EPC STORMWATER REVIEW COMMENTS ARE SHOWN IN ORANGE BOXES WITH BLACK TEXT

WIDEFIELD WATER AND SANITATION DISTRICT
ROLLING HILLS 2MG POTABLE WATER TANK
FEMA FLOODPLAIN MAP

80% DESIGN

**C7**  
 SHEET 10 OF 32

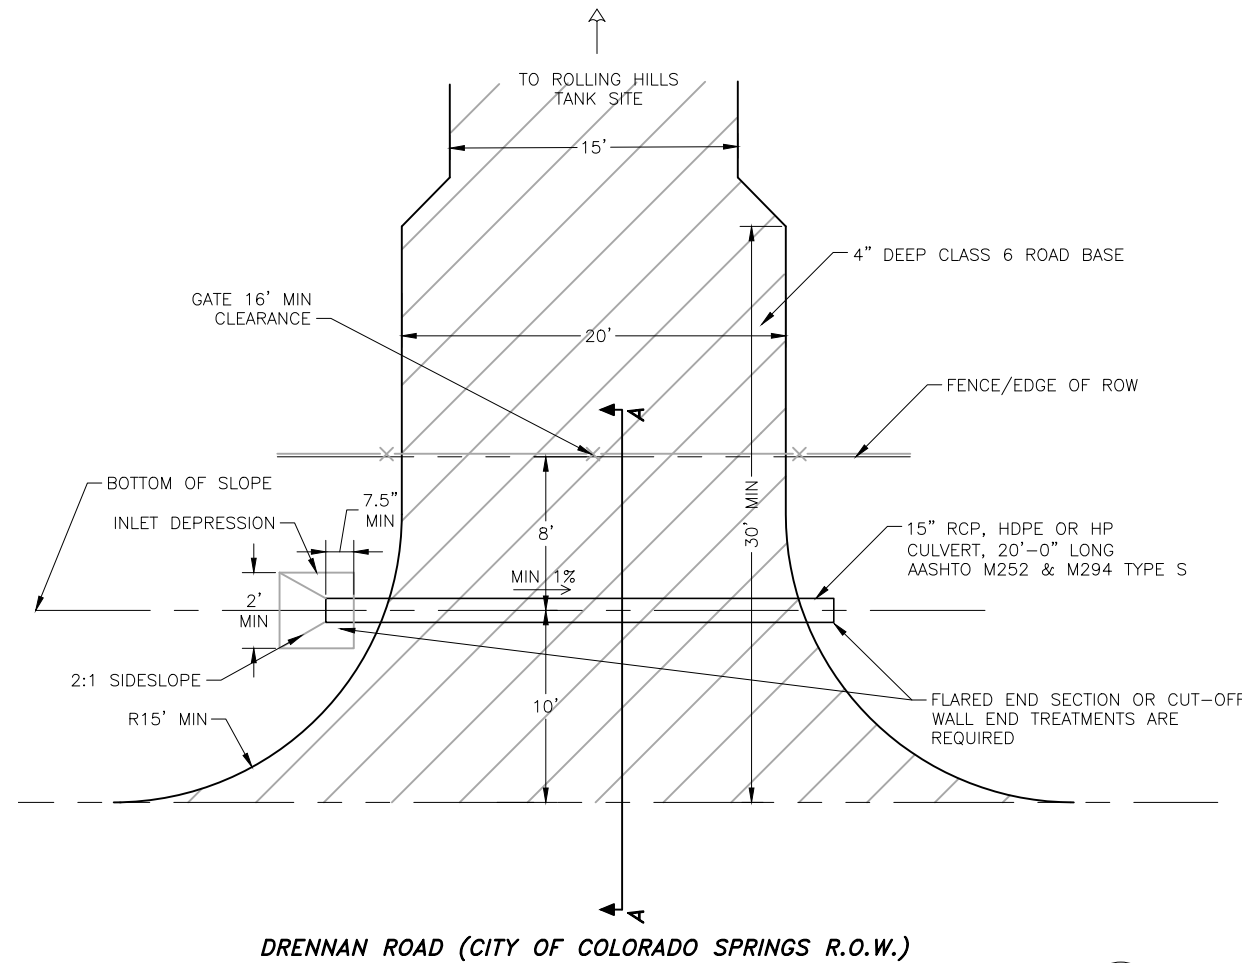
Please revise so that the type of culvert is consistent.

Please identify on the plans where the grass swale adjacent to the access drive is triangular and where it is trapezoidal.

**Table 703-7**  
**GRADITION SPECIFICATIONS FOR FILTER MATERIAL**

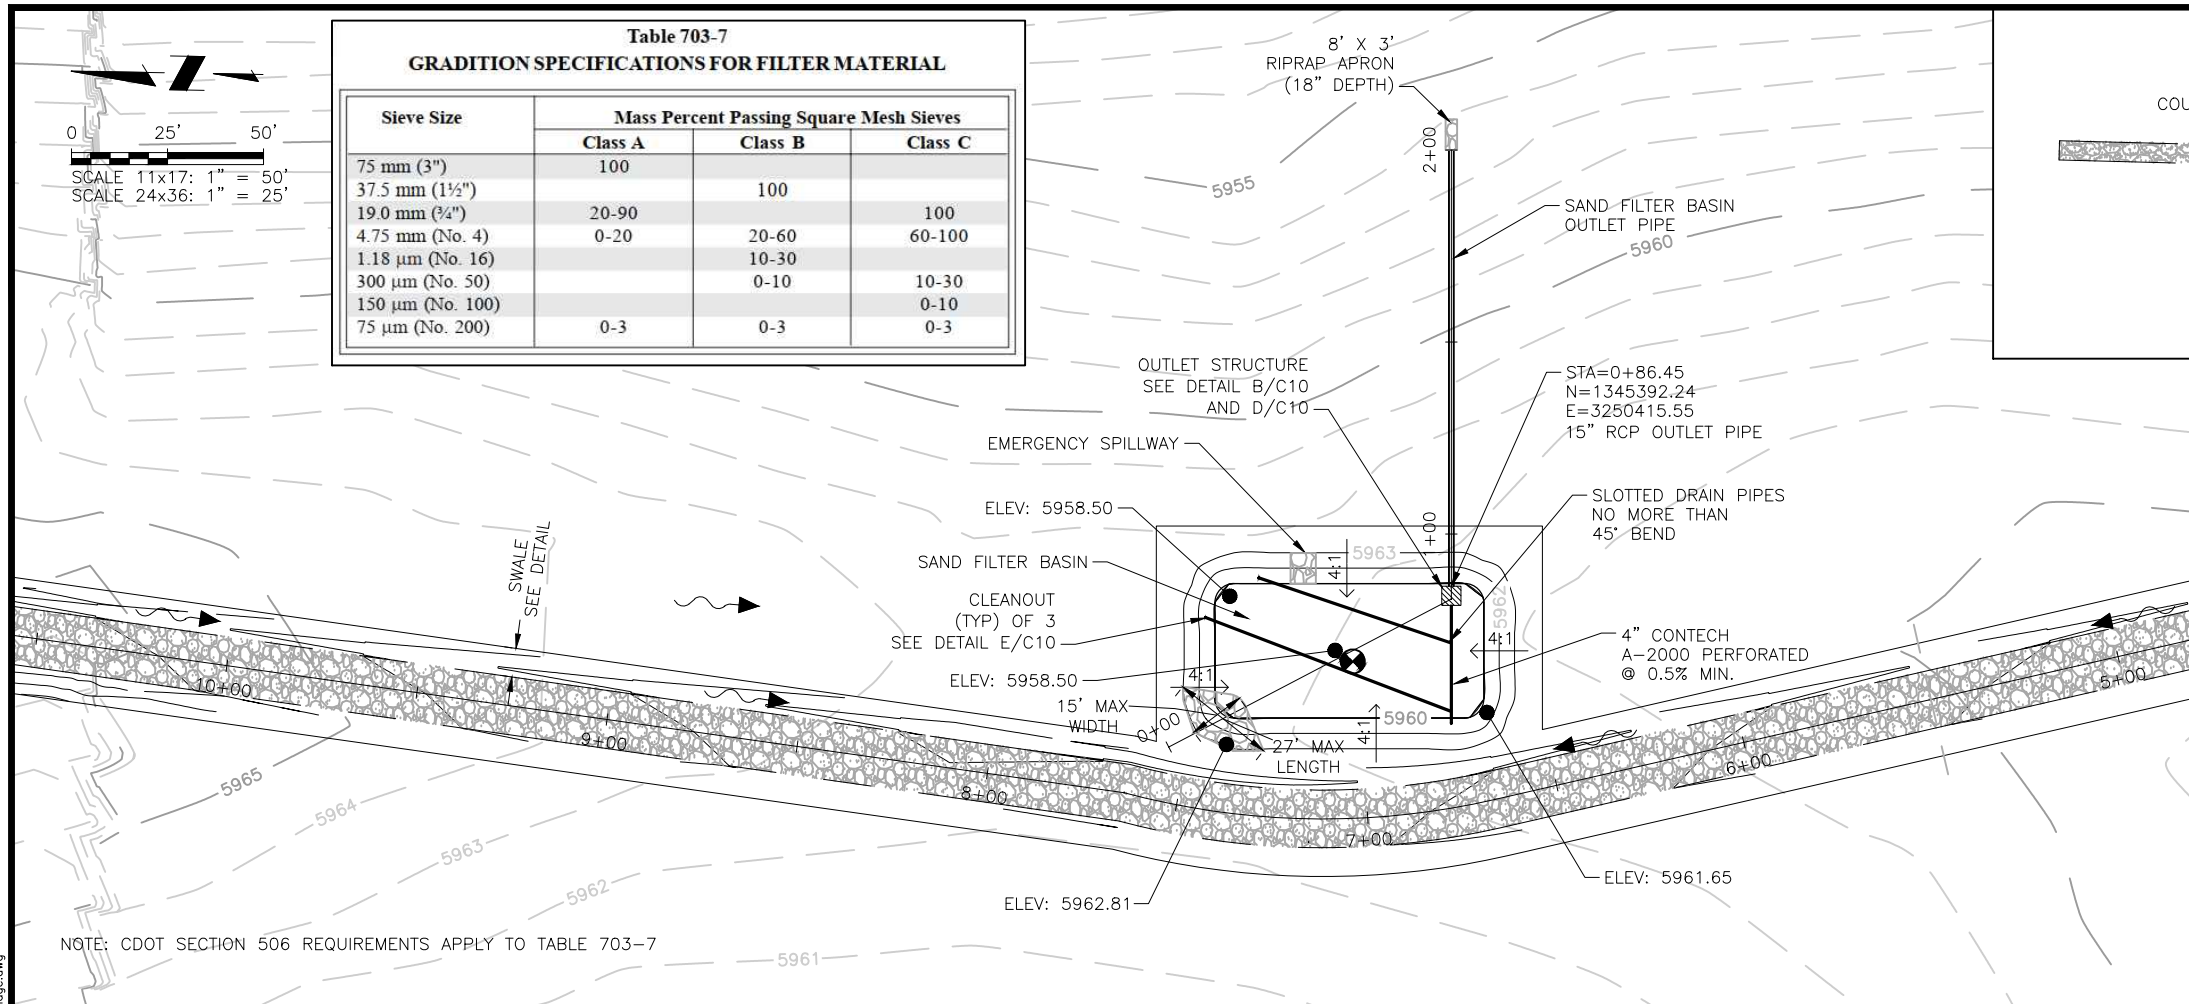
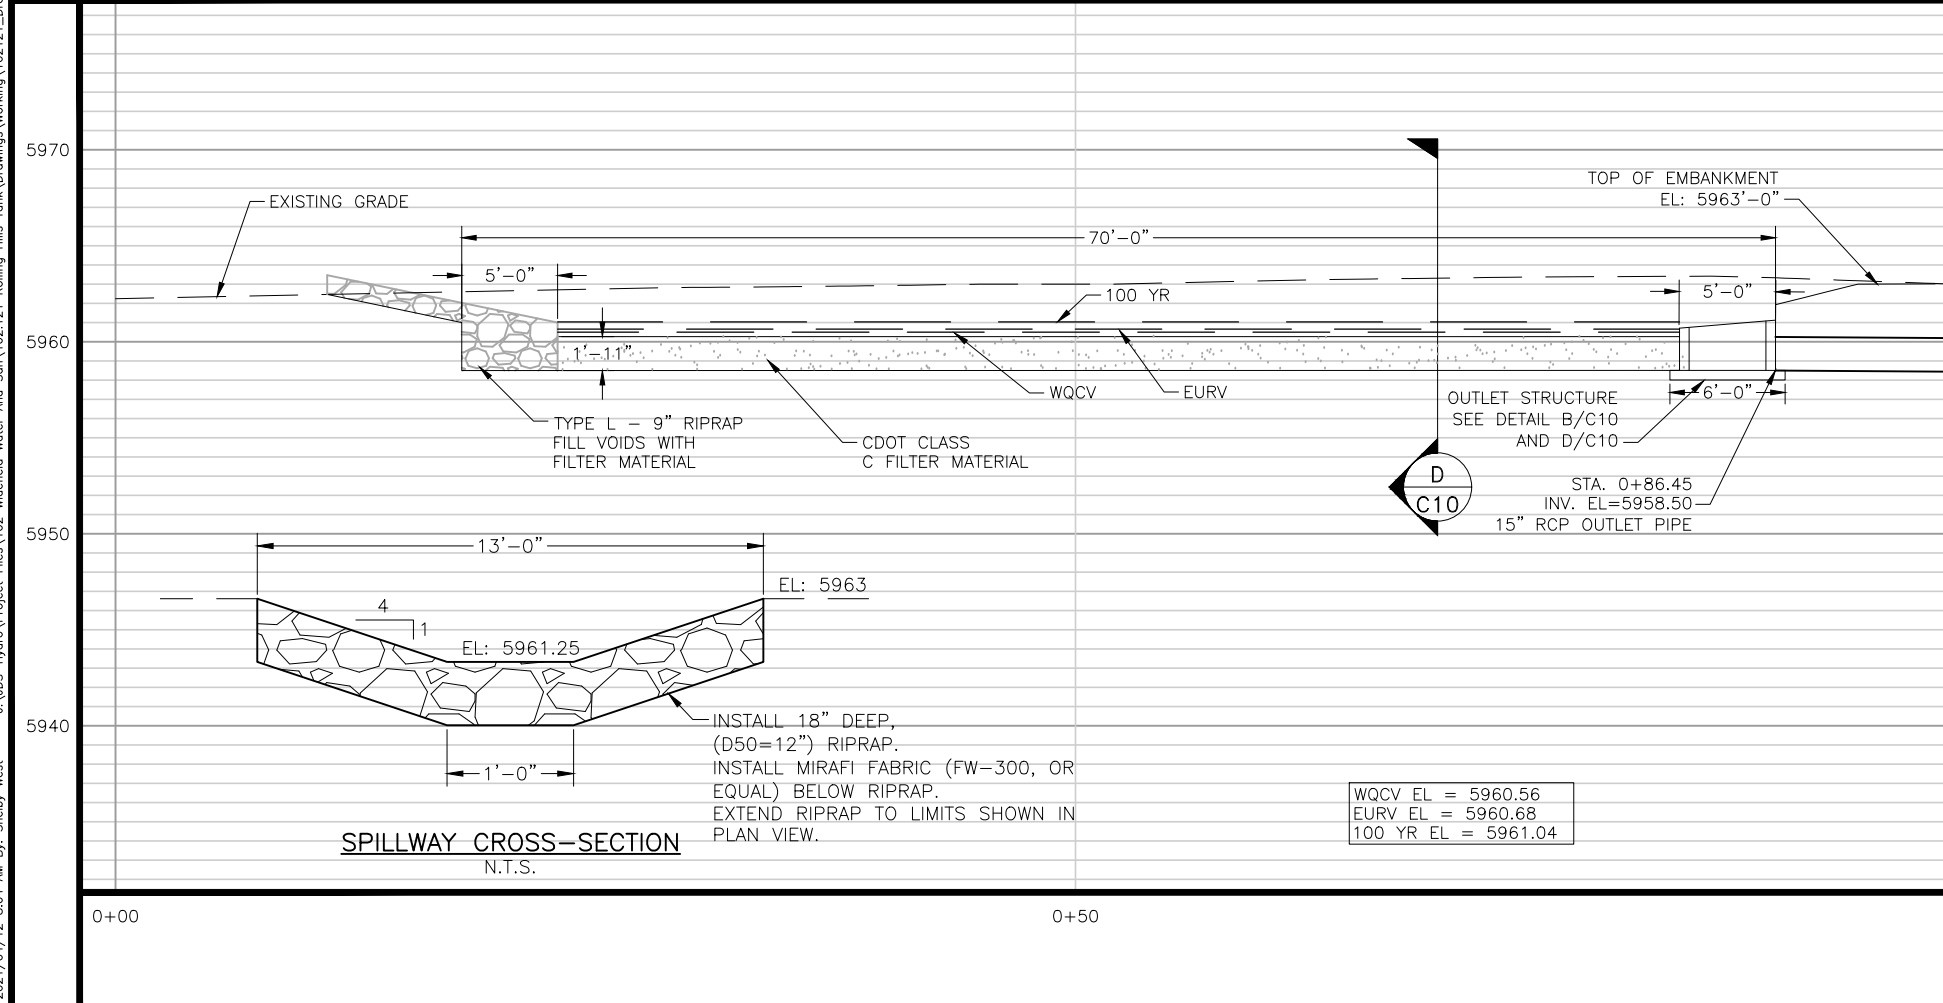
Provide table for filler material

Provide riprap gradation table and note that CDOT Section 506 Requirements apply
